From: Zac Denton
Sent: 10 September 2019 12:08
To: [REDACTED]
Cc: Nicola Spencer
Subject: RE: 50 Torton Hill Arundel, AB/73/19/HH

From: [REDACTED]
Sent: 04 September 2019 14:34
To: 'Zac.Denton@arun.gov.uk' <Zac.Denton@arun.gov.uk>
Subject: 50 Torton Hill Arundel, AB/73/19/HH

JOB NO.	DRAWING NO.	REVISION
-	2.01	E

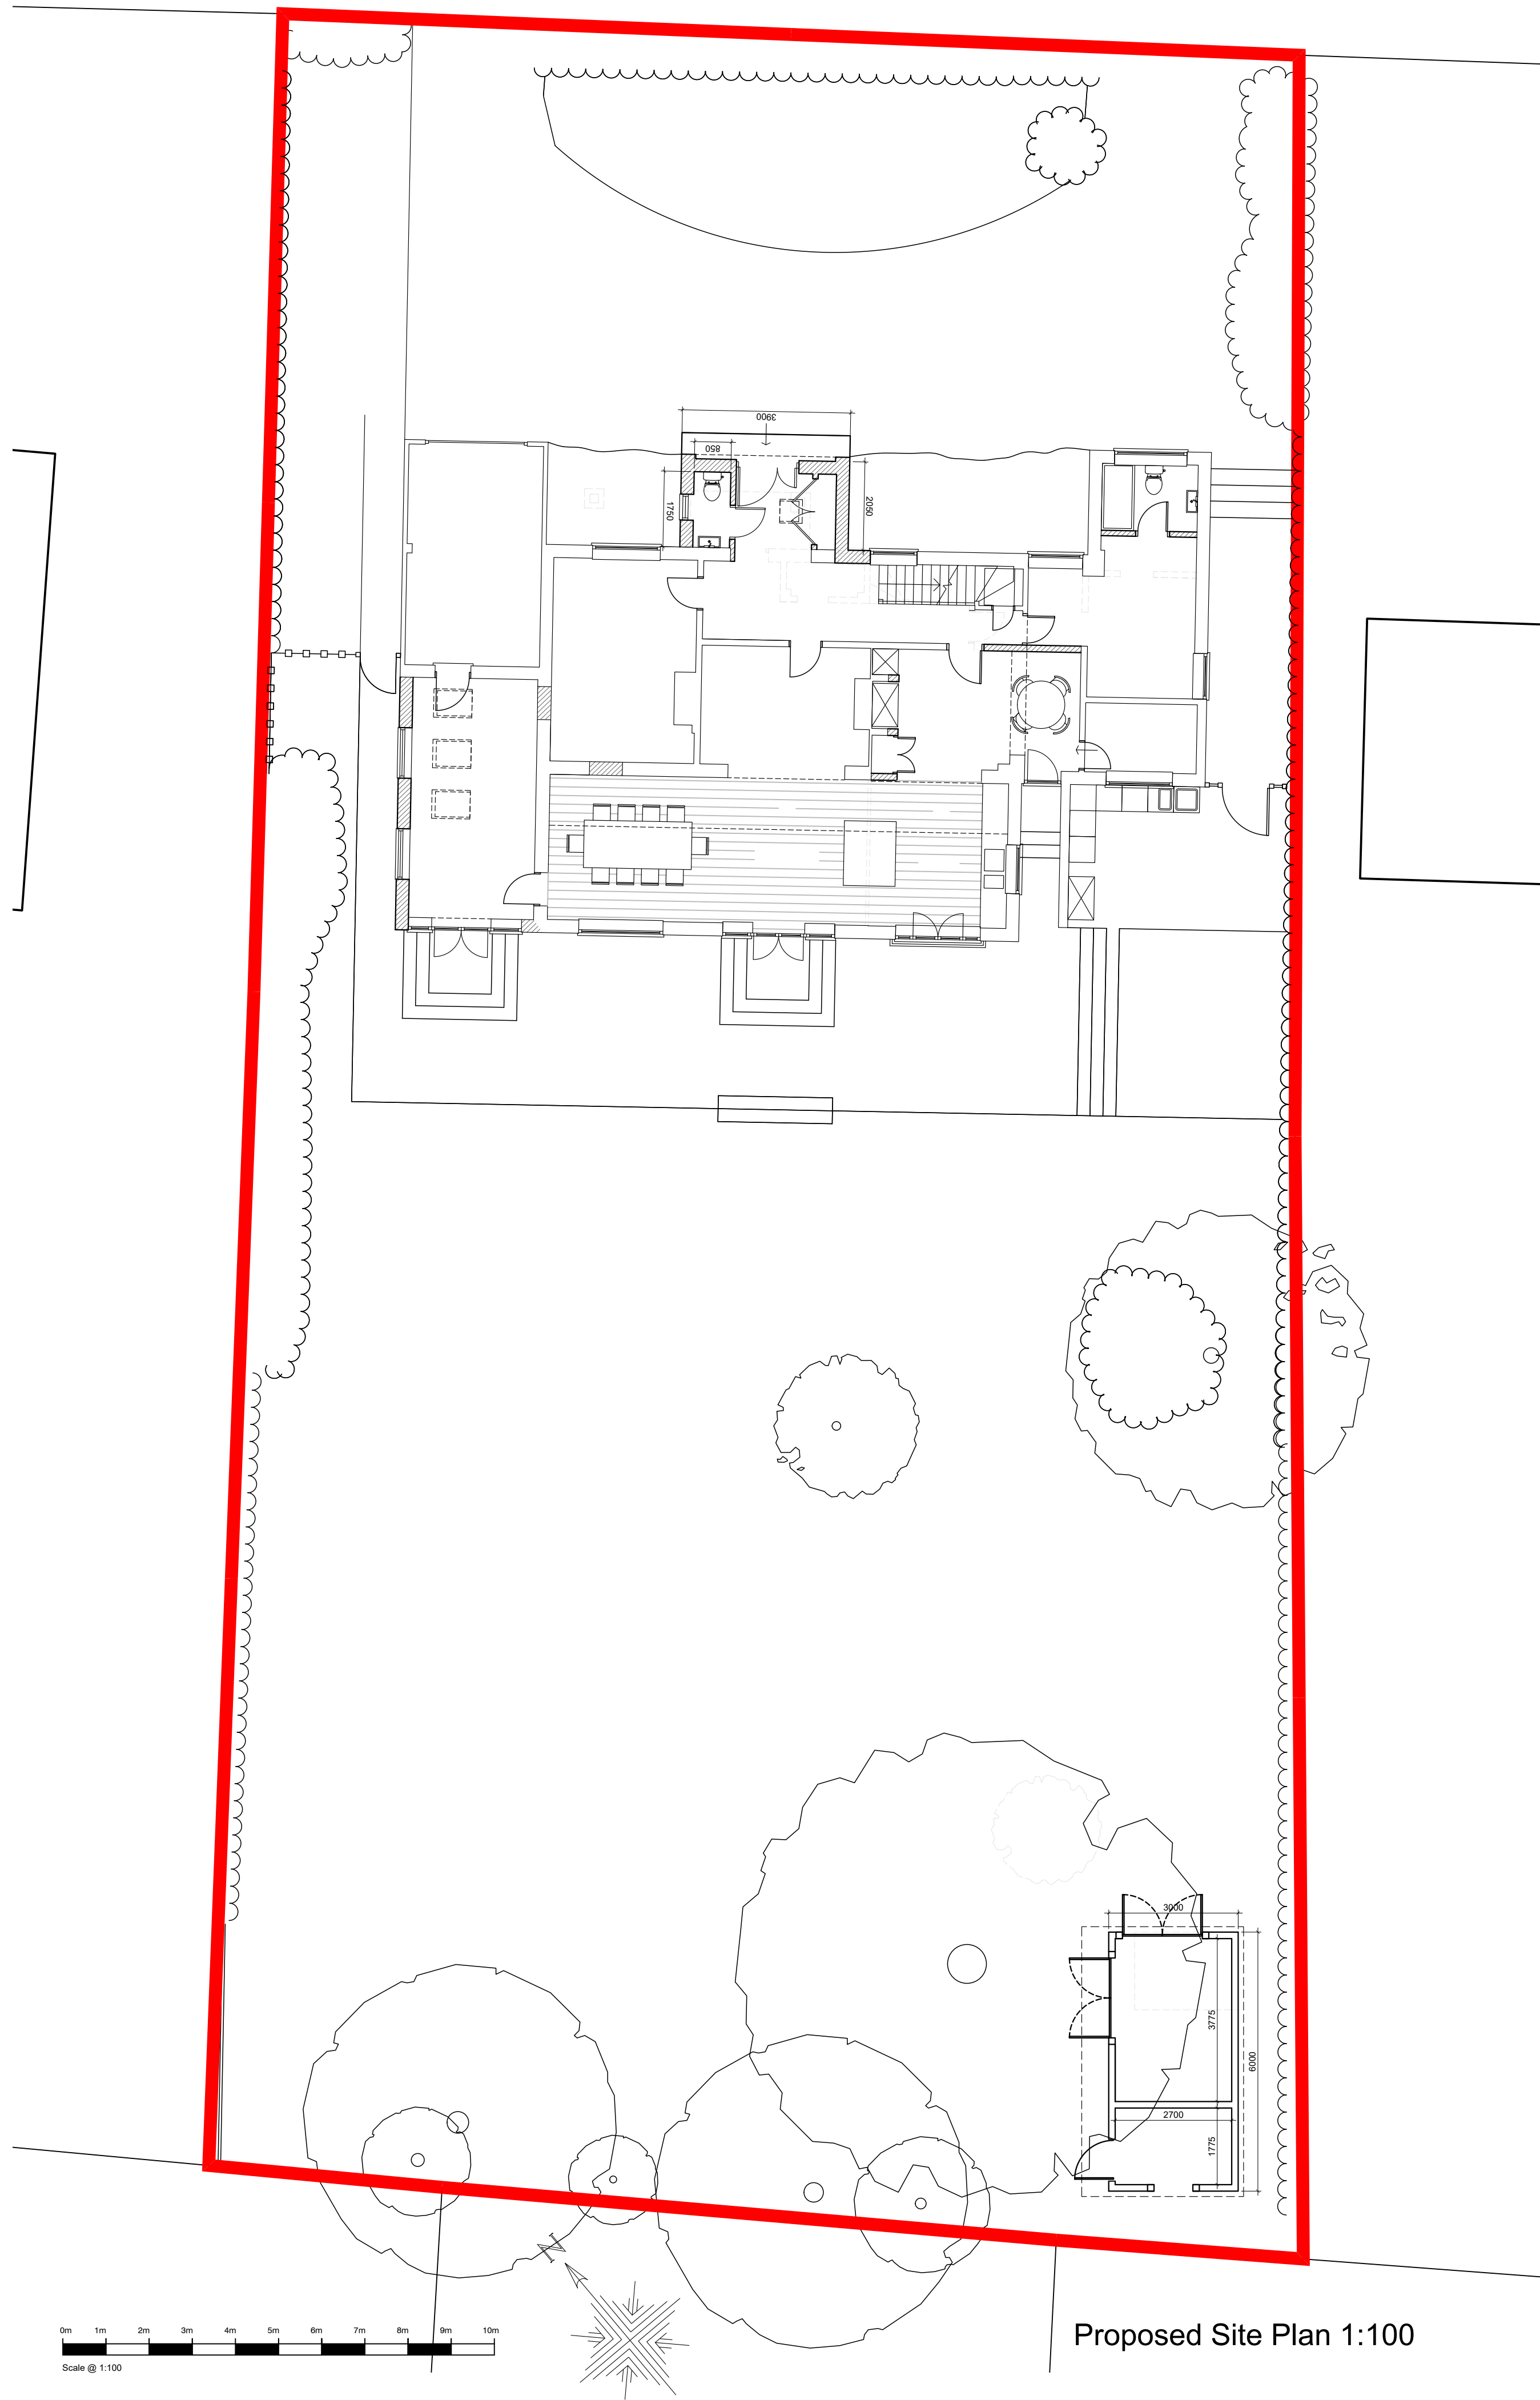
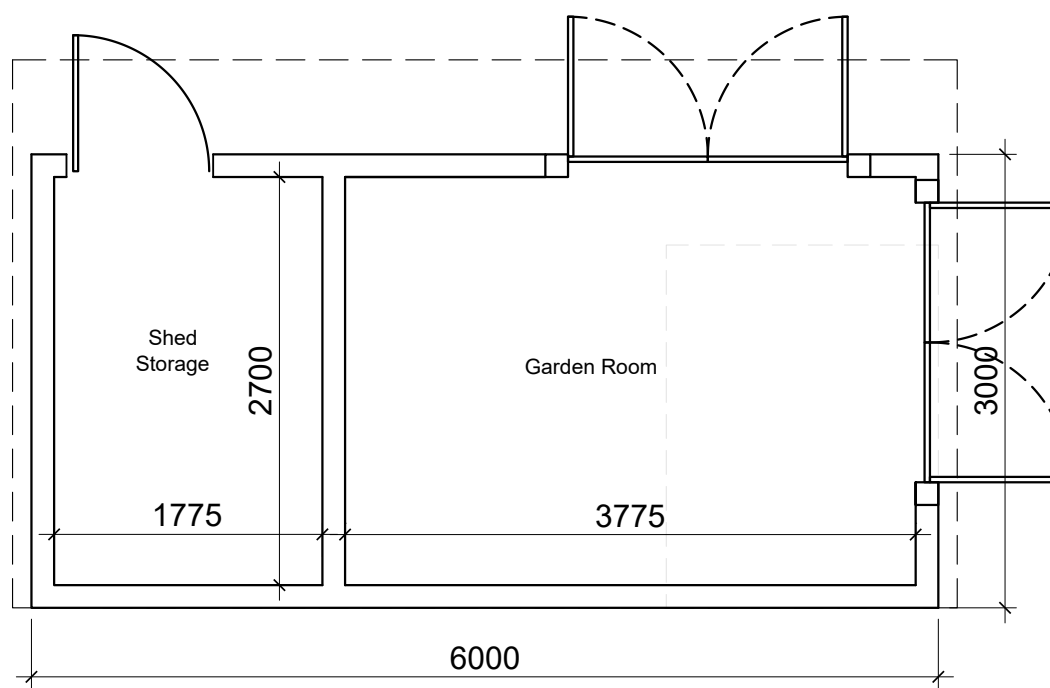
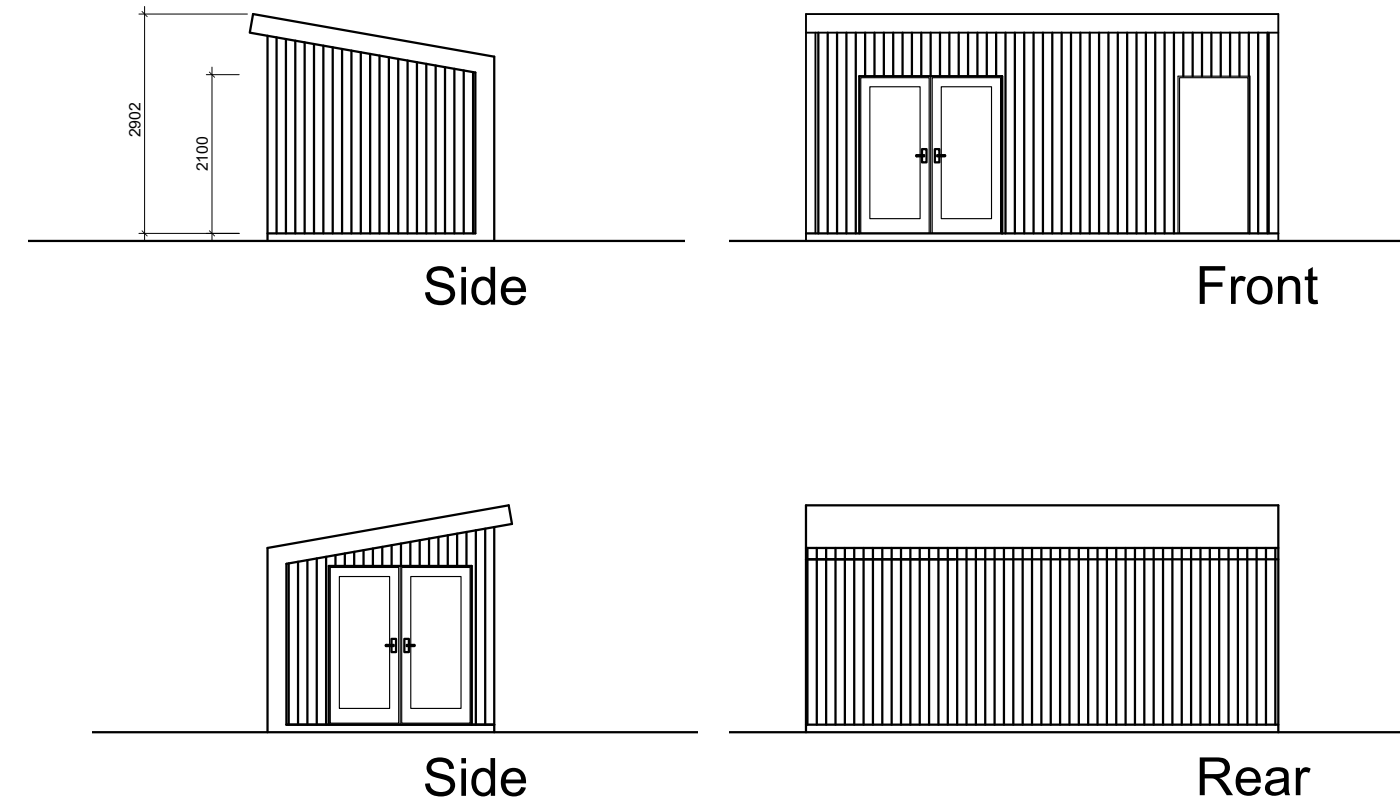
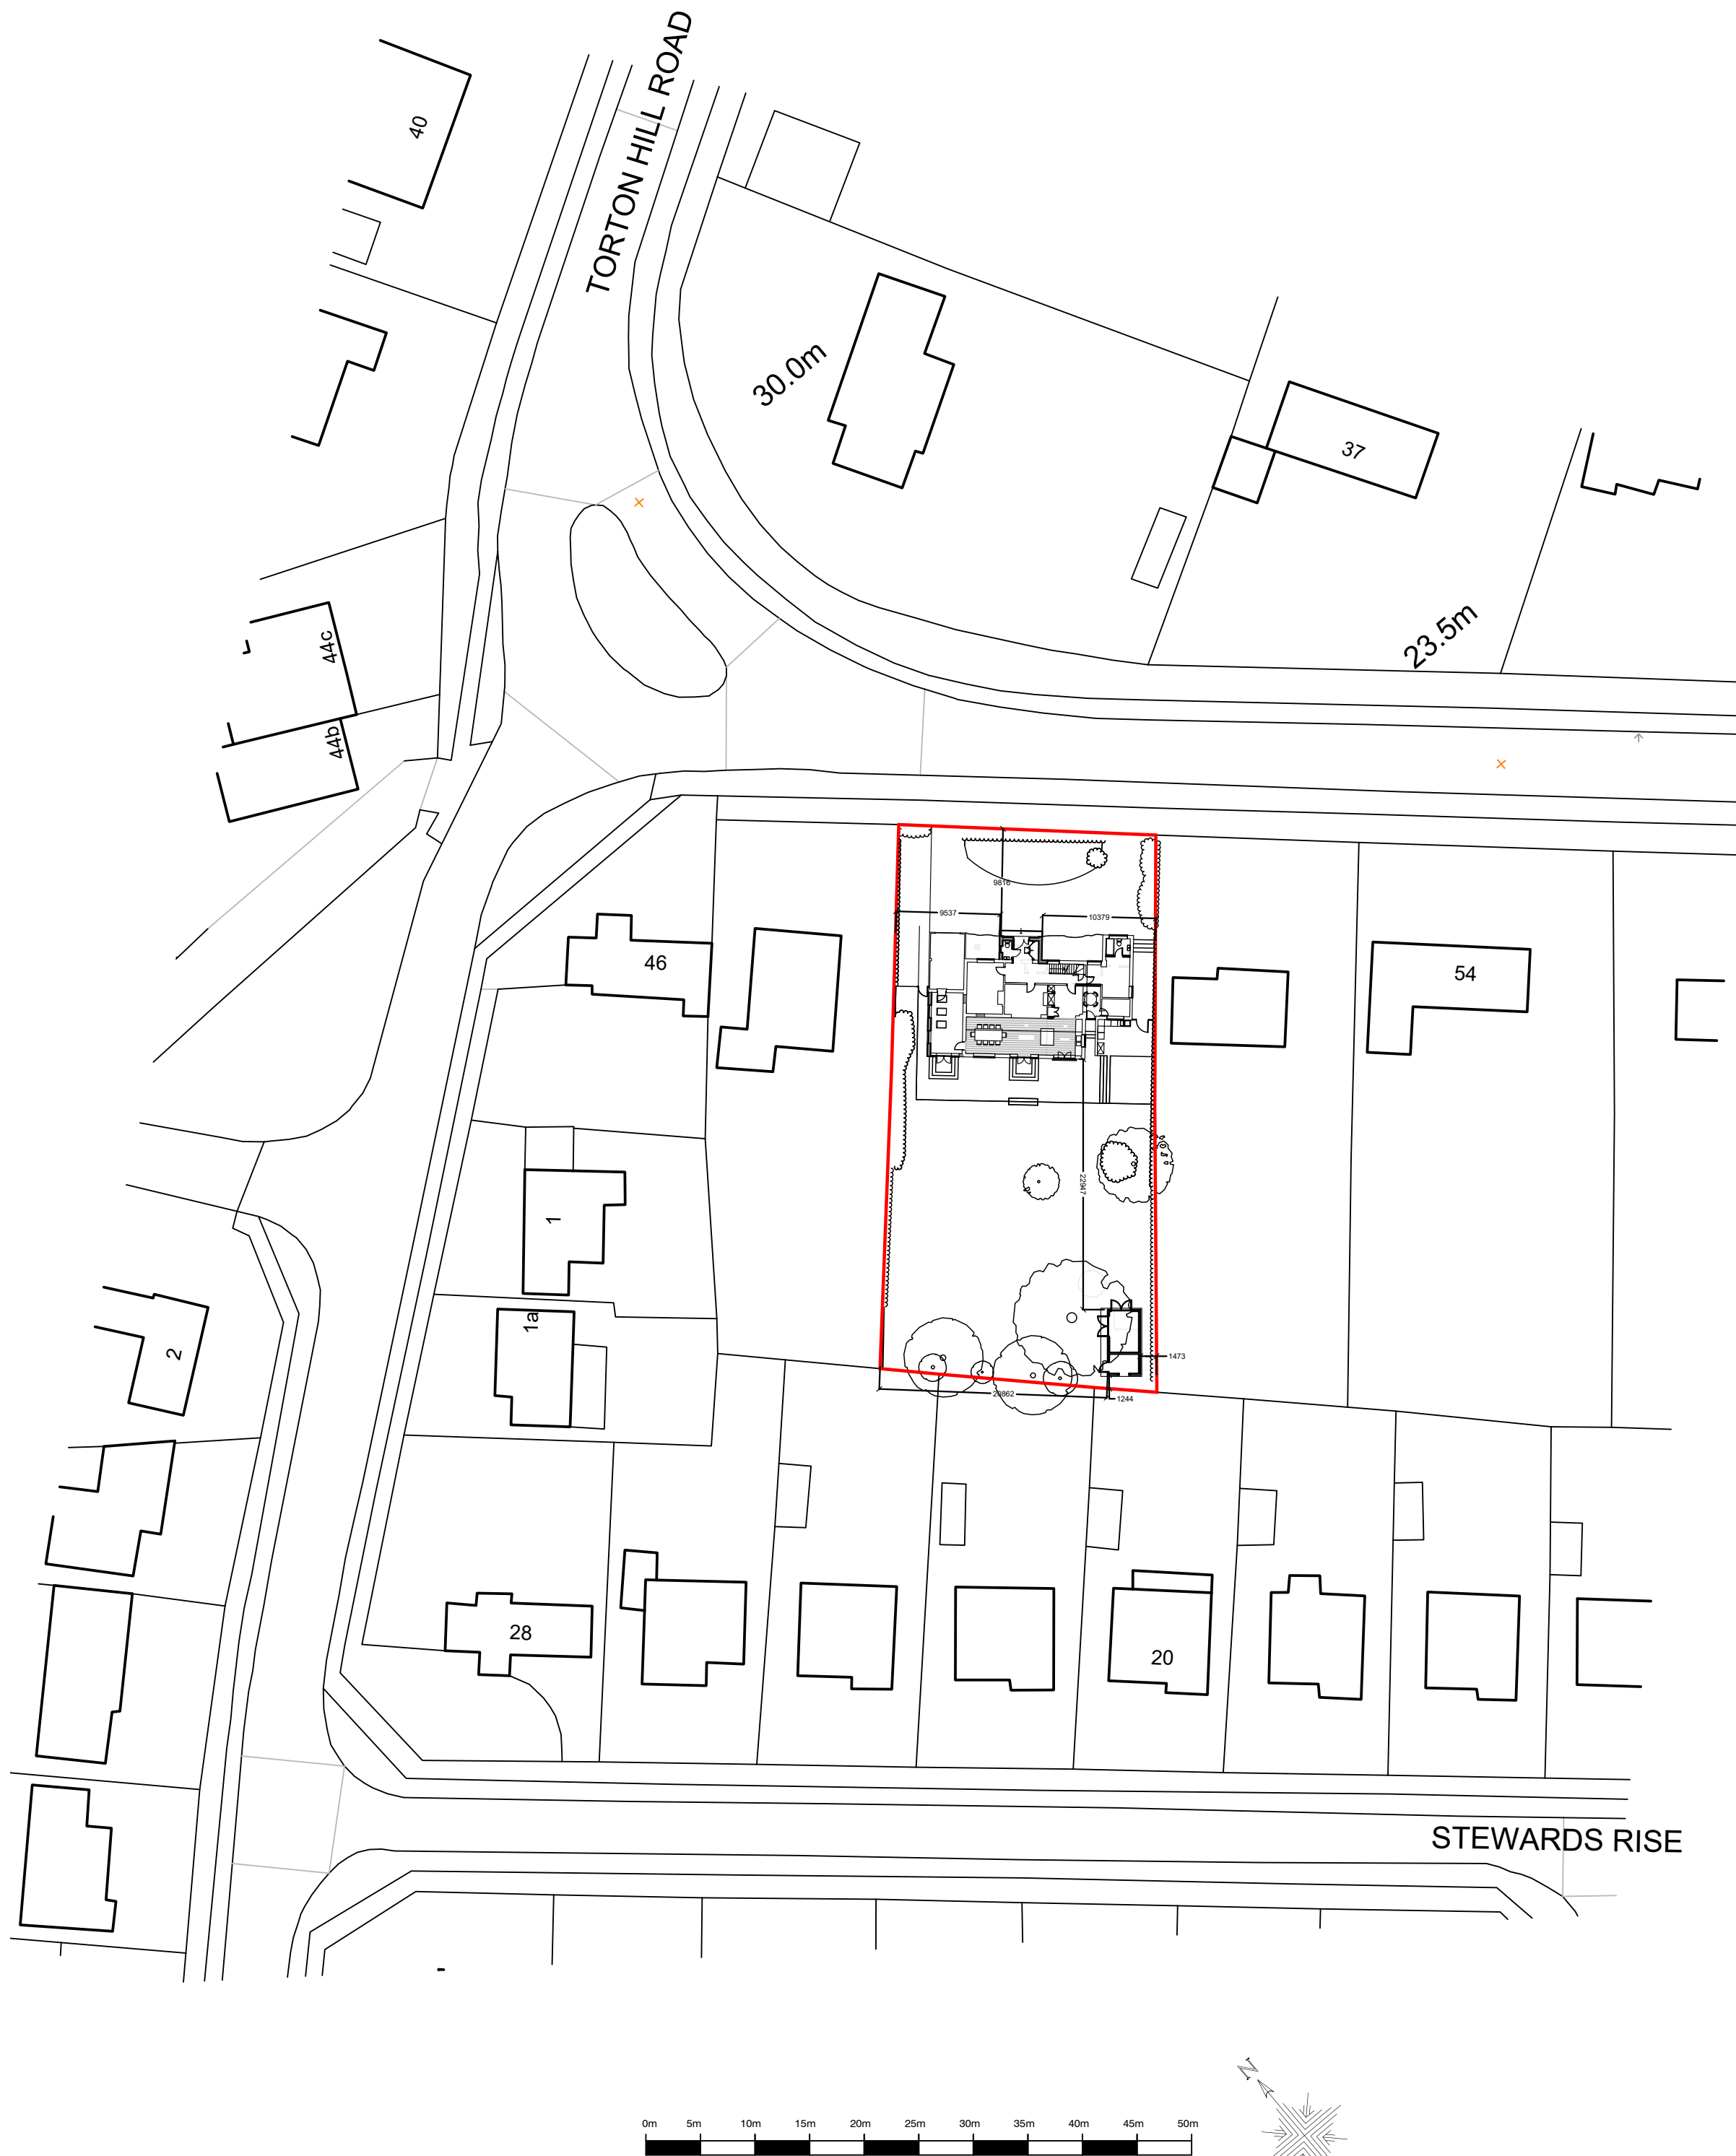
Further to our email last week regarding the re-orientation of the proposed garden building/Shed at 50 Torton Hill Road, I note that this drawings was not included on the conditions schedule on the approval received today.

Further to our telephone conversation, please find attached our amended drawings 2.01E indicating the revised position and design of the garden building. I would be grateful if you could substitute this drawing as part of the application.

I apologise for this issue, I can confirm that the garden building, as shown in the Revision 'E' plan is acceptable, and that this was an error. I will speak to the Technical Support Manager about re-issuing the decision notice.
